From: Sue Field
Sent: 31 May 2023 10:39
To: Planning.Responses
Subject: FW: WA/56/22/PL Land East of Fontwell Avenue - Variation of condition to provide 5 affordable units above approved shop.
Attachments: 4736-DAN-RET-04G.PDF; 4736-DAN-RET-02D.PDF

Subject: [EXTERNAL] WA/56/22/PL Land East of Fontwell Avenue - Variation of condition to provide 5 affordable units above approved shop.

FIRST FLOOR PLAN

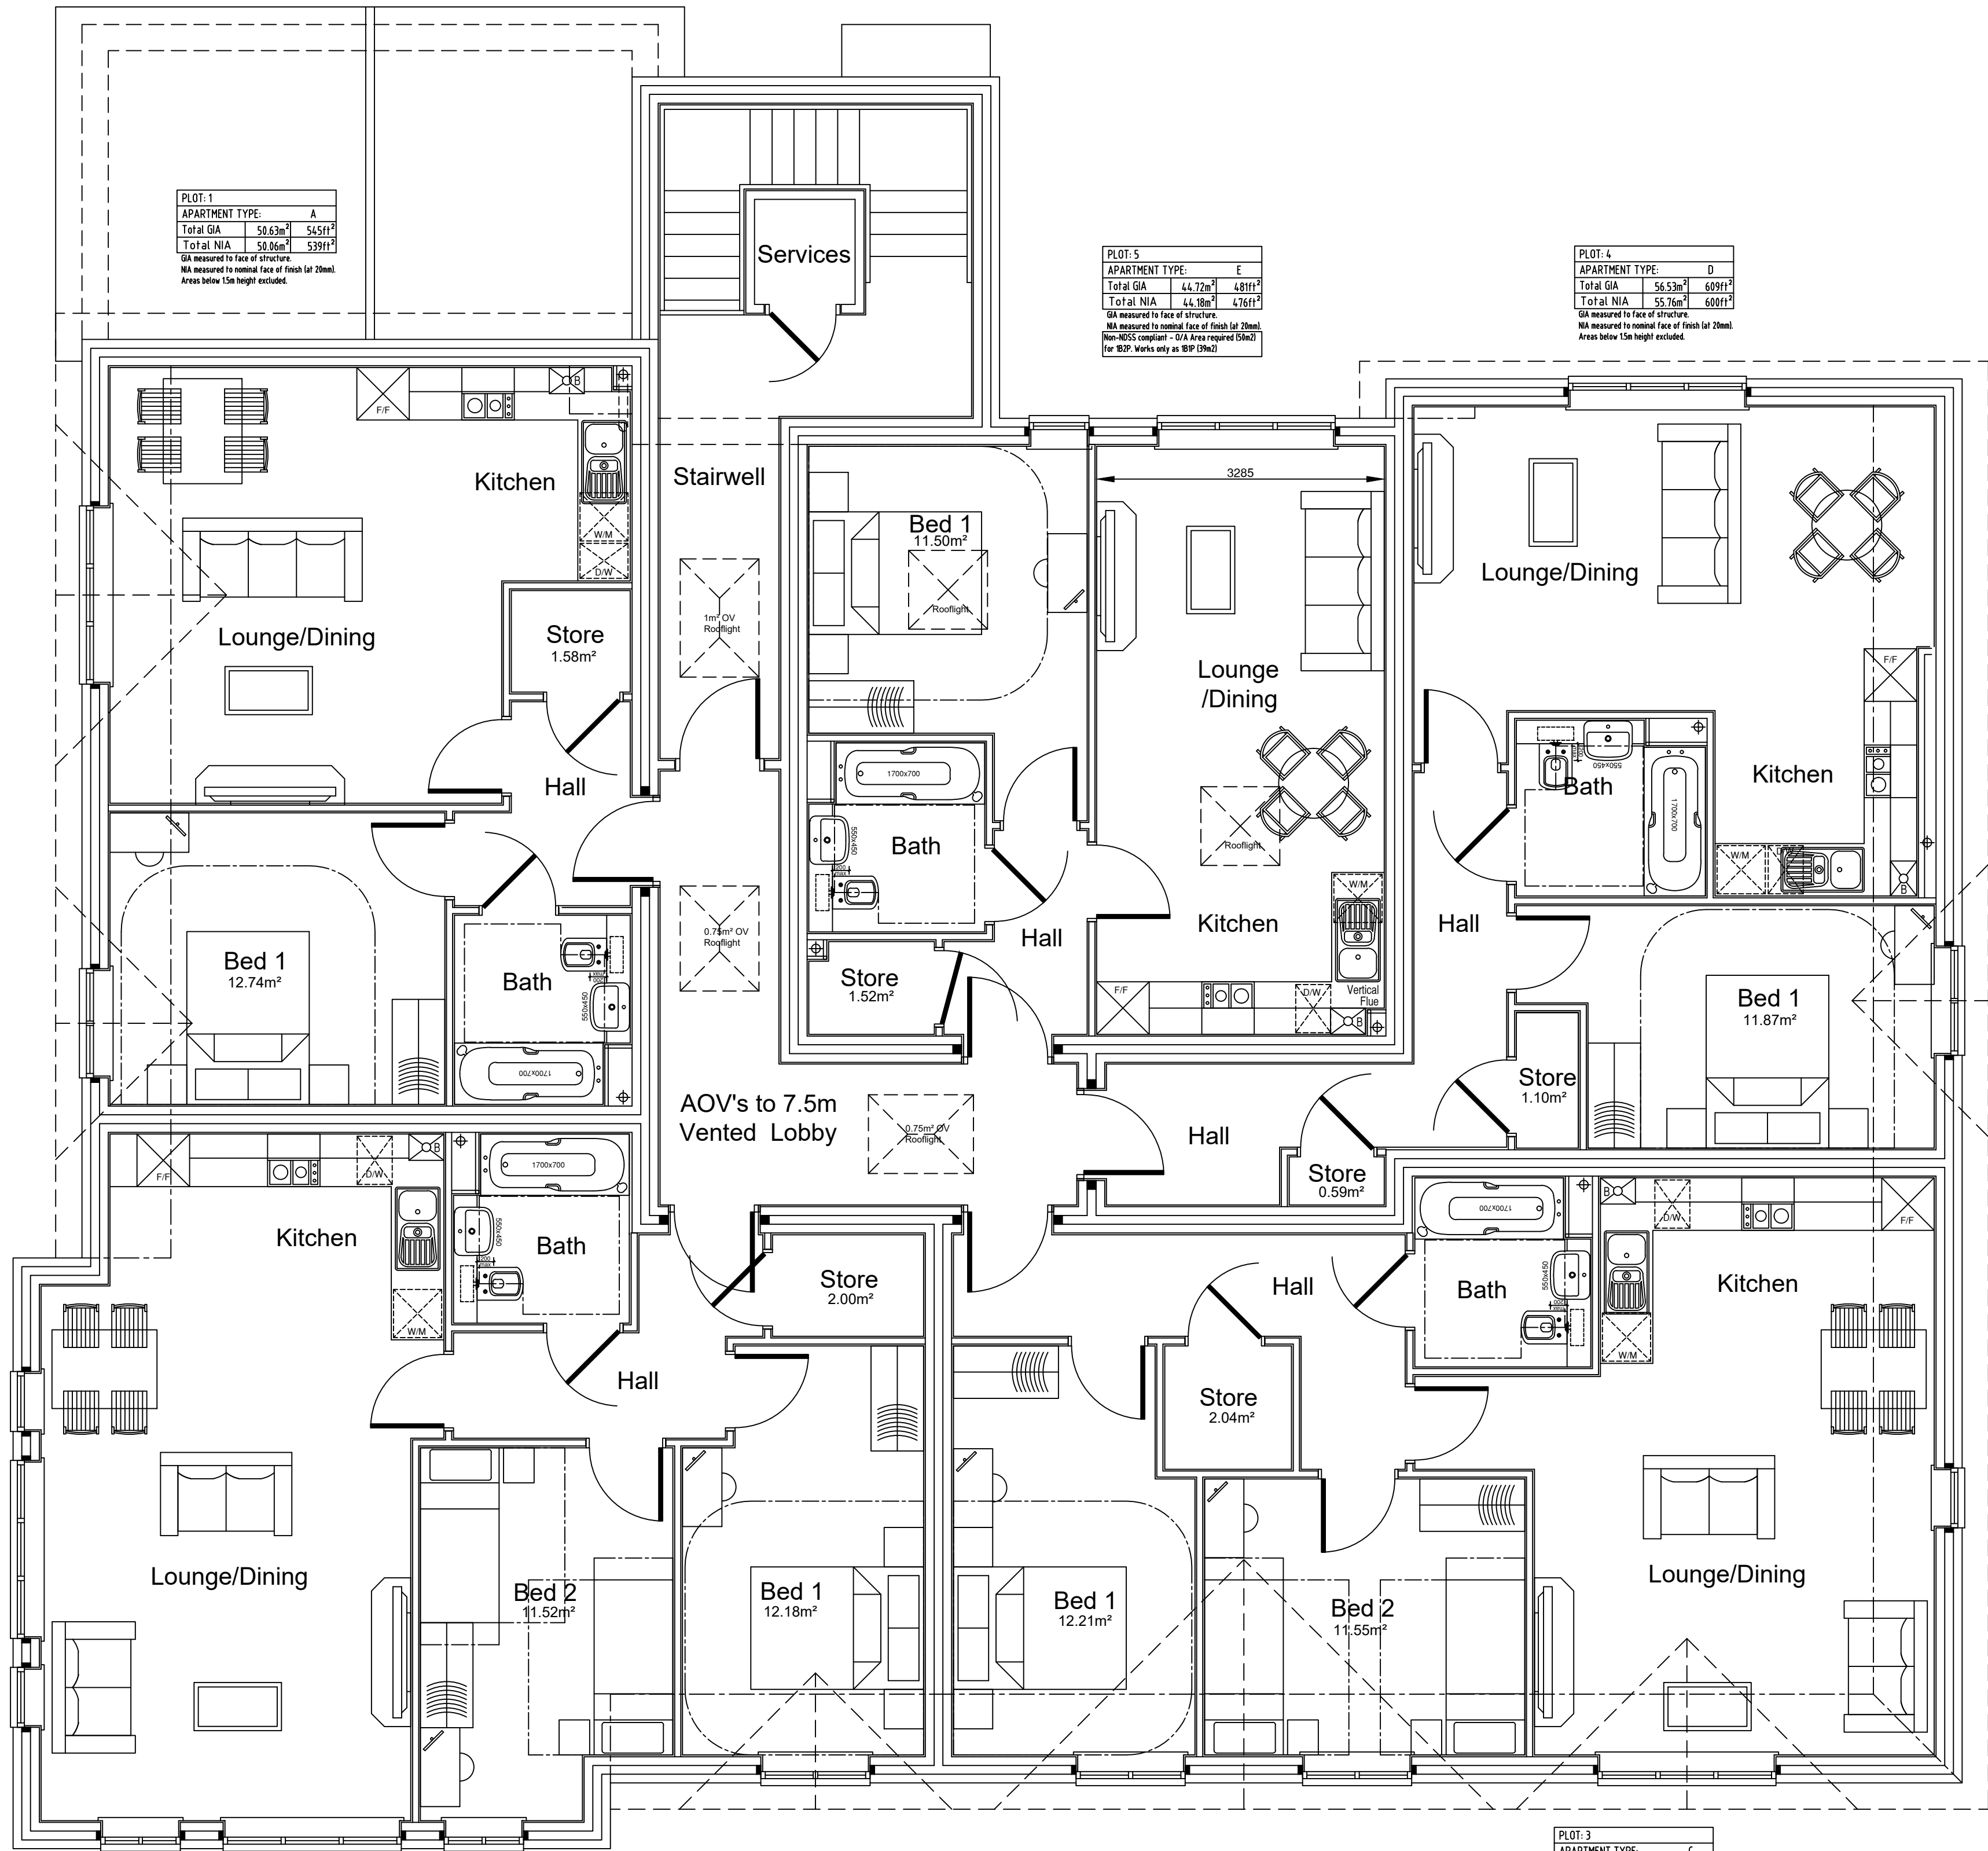
May I return to the question of NDSS. In your email dated 10 May, you confirmed that all the dwellings were now NDSS compliant and that this was shown on the proposed first floor plans - Drawing No. 4736/DAN/RET/02 B. (which I have attached). However, this drawing shows that whilst plots 1 to 4 are NDSS compliant, plot 5 is still under the 50sqm requirement @ 44.7sqm.

It would also appear that this drawing has subsequently been superseded by Drawing No. 4736/DAN/RET/02 Rev C – proposed first floor (also attached). However, this drawing shows that Plots 3 and 5 are not NDSS compliant. As it is

clear that from looking at Rev C, that plot 5 has been increased in size (with plot 4 being deceased) I am presuming that the table has not been updated? It's not obvious why Plot 3 has decreased, but again I am presuming this is to allow for the increase to plot 5 and alterations to plot 4 and that the table just needs updating.

Also, in regard to the question raised on natural light/purge to plot 5. I appreciate you confirmed that the window size had increased from 600mm wide to 910mm wide, but again comparing the first floor plans (Rev B & Rev C) the window appears to be the same size. May I suggest that as the plan needs to be amended in regard to NDSS, that the size of the window to bed 1 on plot 5 is annotated on the plan. This will then allow me to clarify that the comments raised by EHO have been addressed within the delegated report.

Sorry for the slight delay, I needed to confirm a few points with architect. It seems the plans hadn't picked up on all, but the attached now do. All units are now NDSS compliant. Please see summary table below and attached updated first floor plans and elevations.

Plot	NDSS	Proposed floor area
1 (1 bed 2 person)	50sqm	50.75sqm
2 (2bed 4 person)	70sqm	70.33sqm
3 (2 bed 3 person)	61sqm	65.9sqm
4 (1bed 2 person)	50sqm	52.2sqm
5 (1 bed 1 person)	39sqm	44.1sqm

The revised plans also address the light levels and purge query. The drawing also includes the requested annotation.
